MP08_0241 - Section 75W Modification Application 100 Mount Street North Sydney – Response to Council, Railcorp and the Department of Transport Submissions

We provide the following response to the matters raised by North Sydney Council, Railcorp and the Department of Transport in relation to the above 75W application.

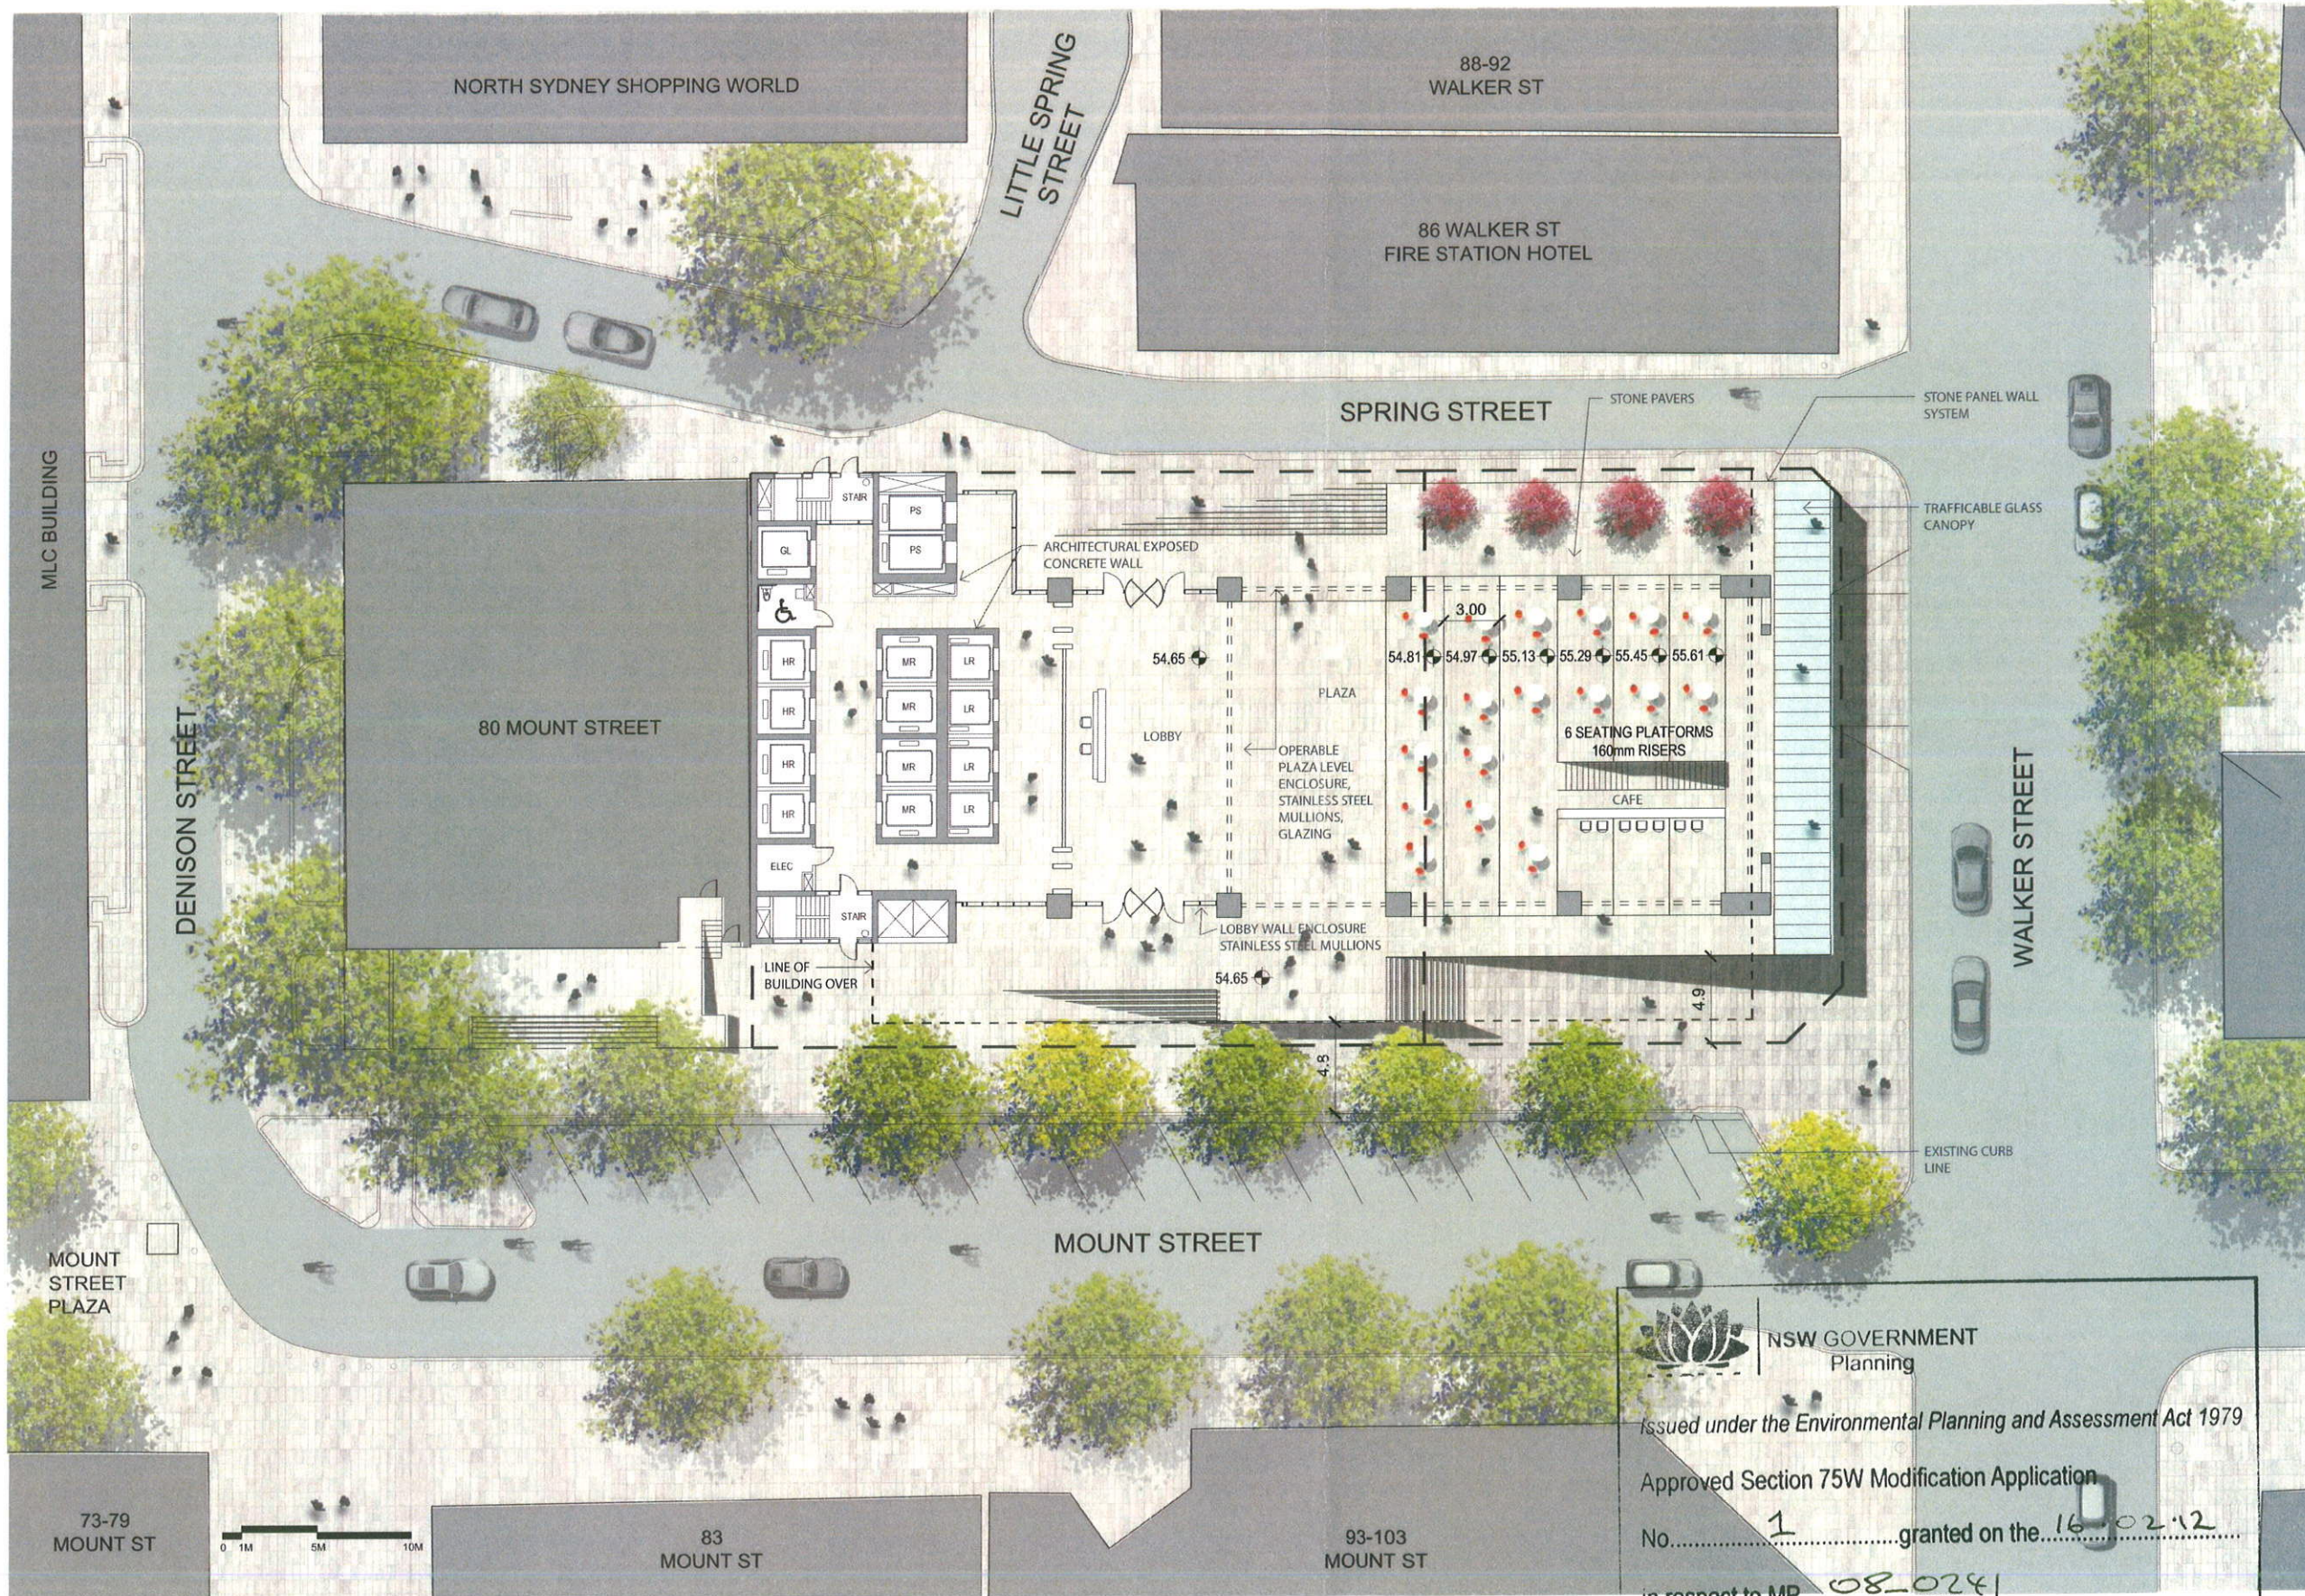
MOUNT STREET AWNING

The extent of the Mount Street awning is considered to be appropriate and satisfactory and no change is proposed for the following reasons:

- Substantial weather protection is provided for pedestrians walking along Mount Street. Due to the setback of the building at ground level, pedestrians are able to move under the proposed 6m wide awning in the event of inclement weather and even traverse the plaza level if that is the desired direction of travel, refer to the attached annotated **DA109-1 Site Diagram – Pedestrian Path Under Canopy**.

DA109-2

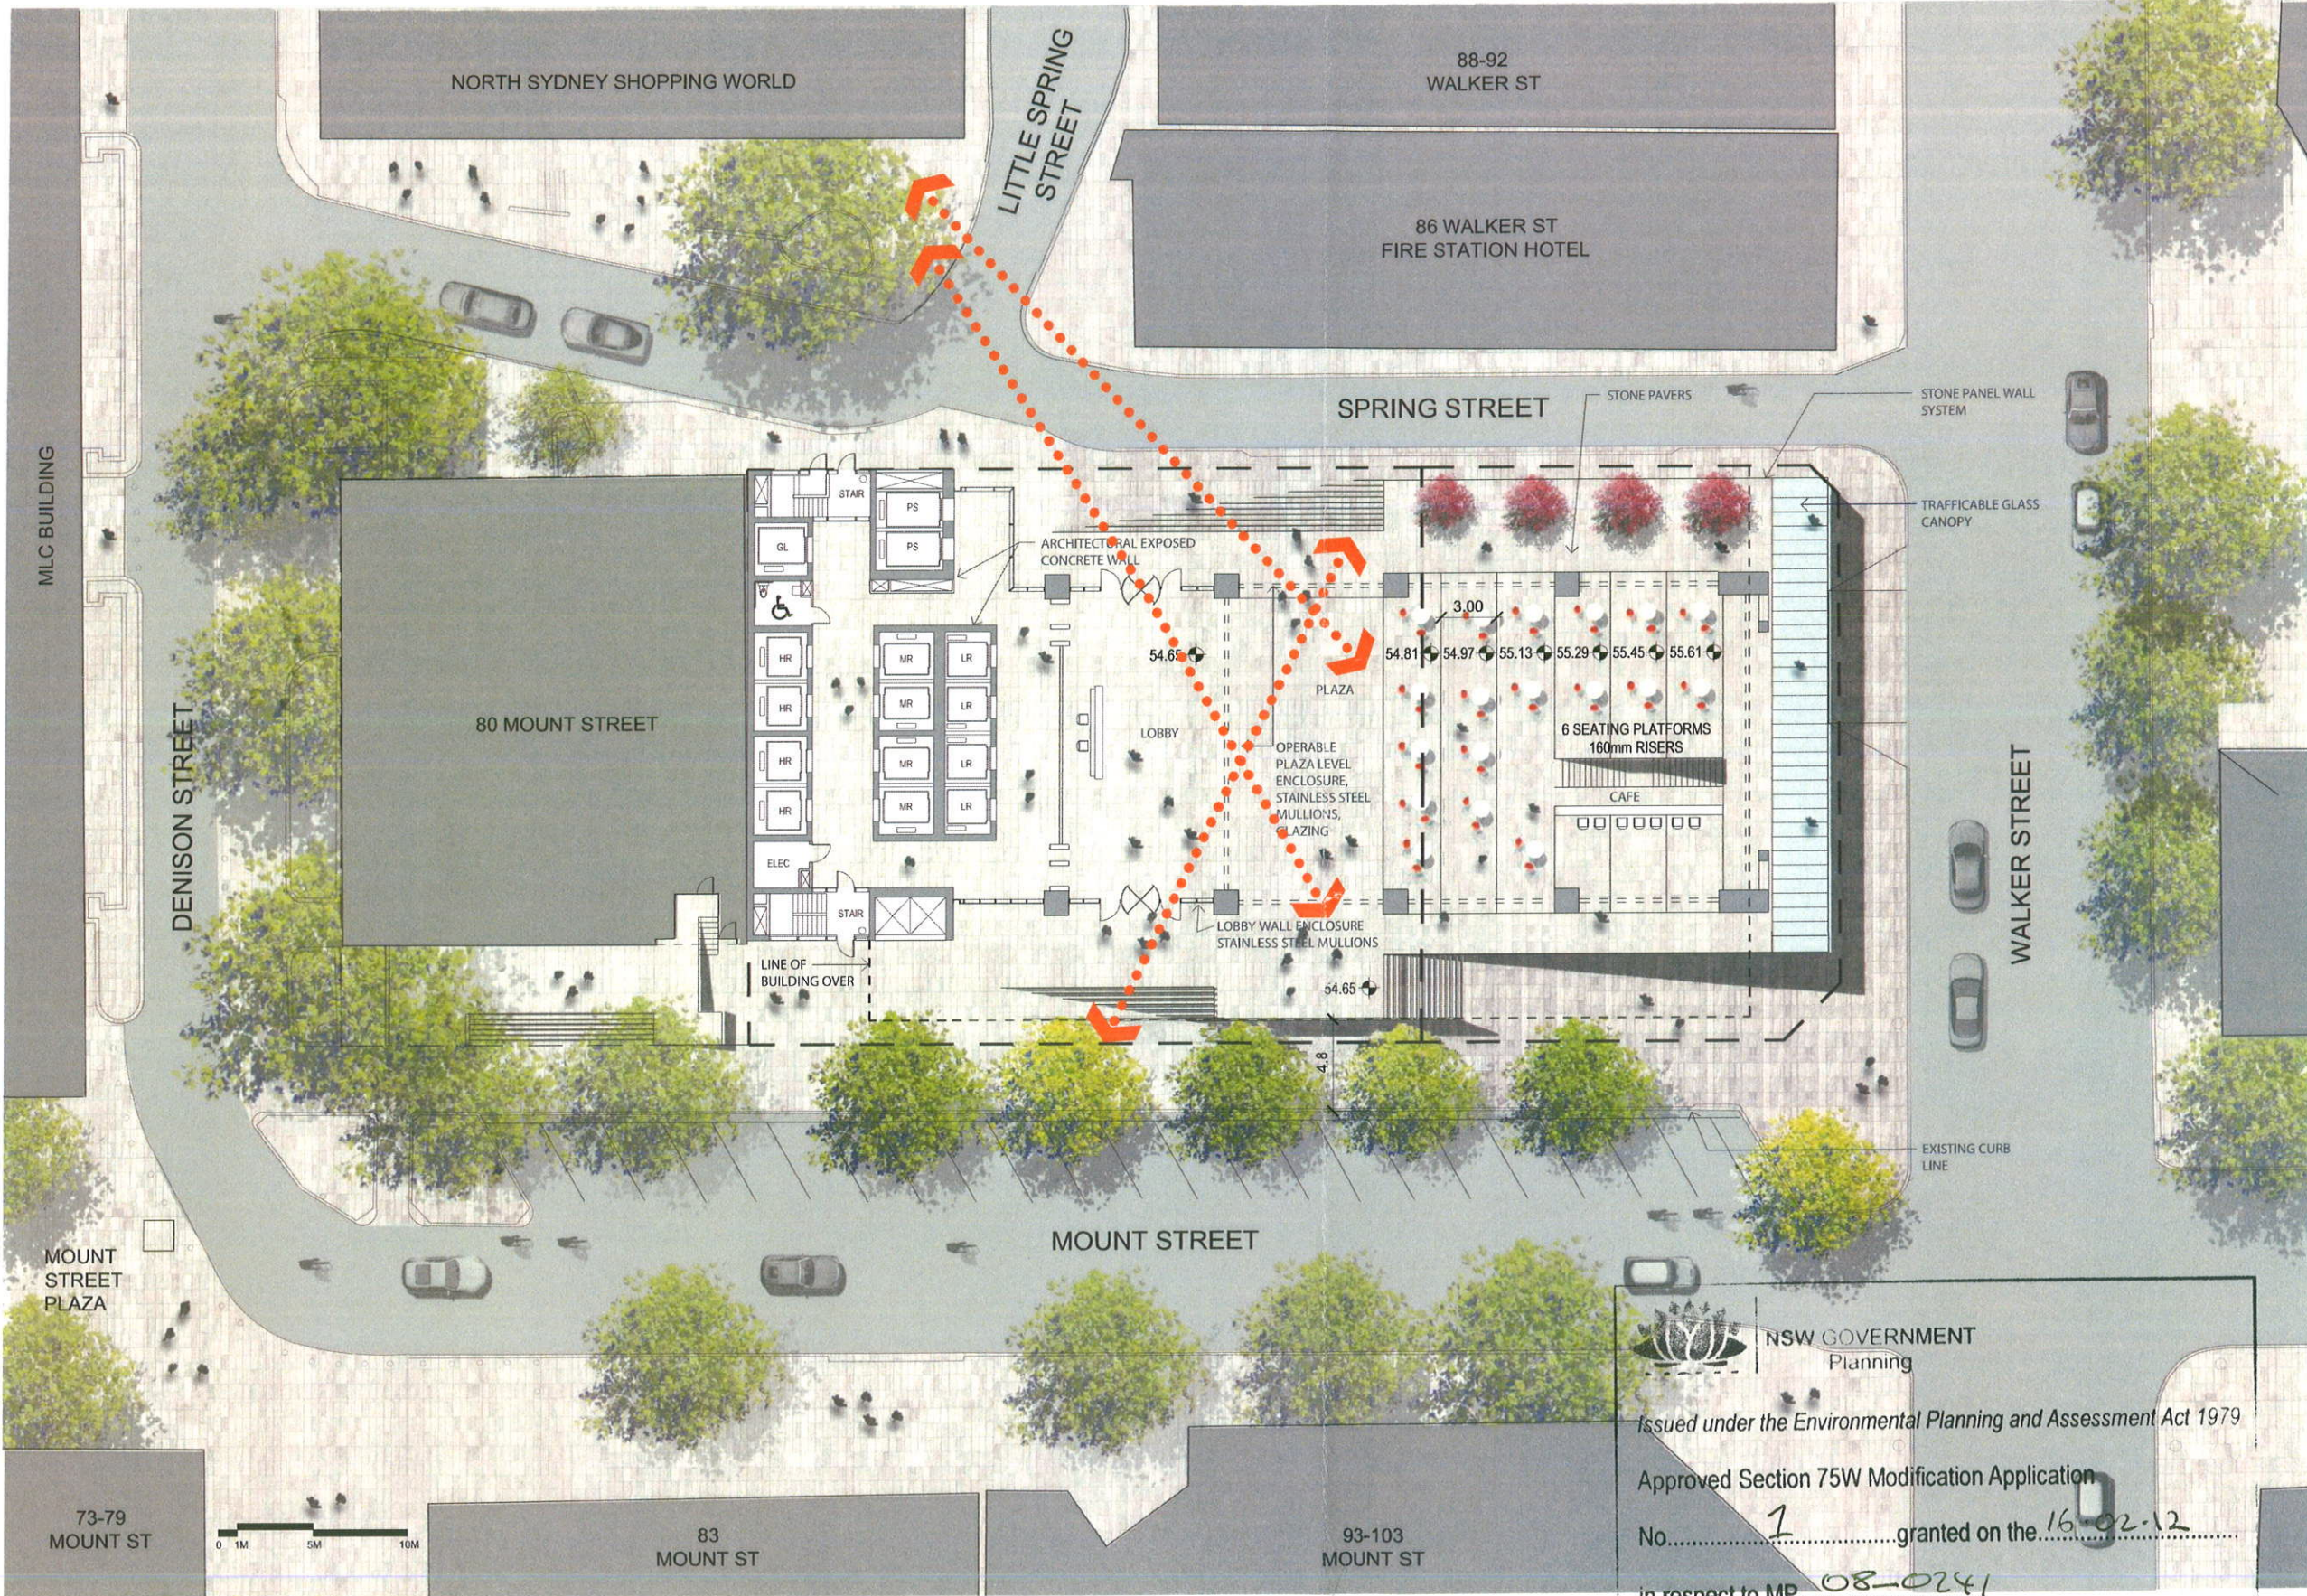
THROUGH SITE LINK

The stair design along Spring Street and Mount Street has been optimised to minimise the number and length of stairs and the length of walling. The angles a pedestrian can cross the site has been maximised. Any further reduction of stairs would increase walling and at the same time decrease the angles available through the site, see attached **DA109-2 Site Diagram – Through Site Link**.
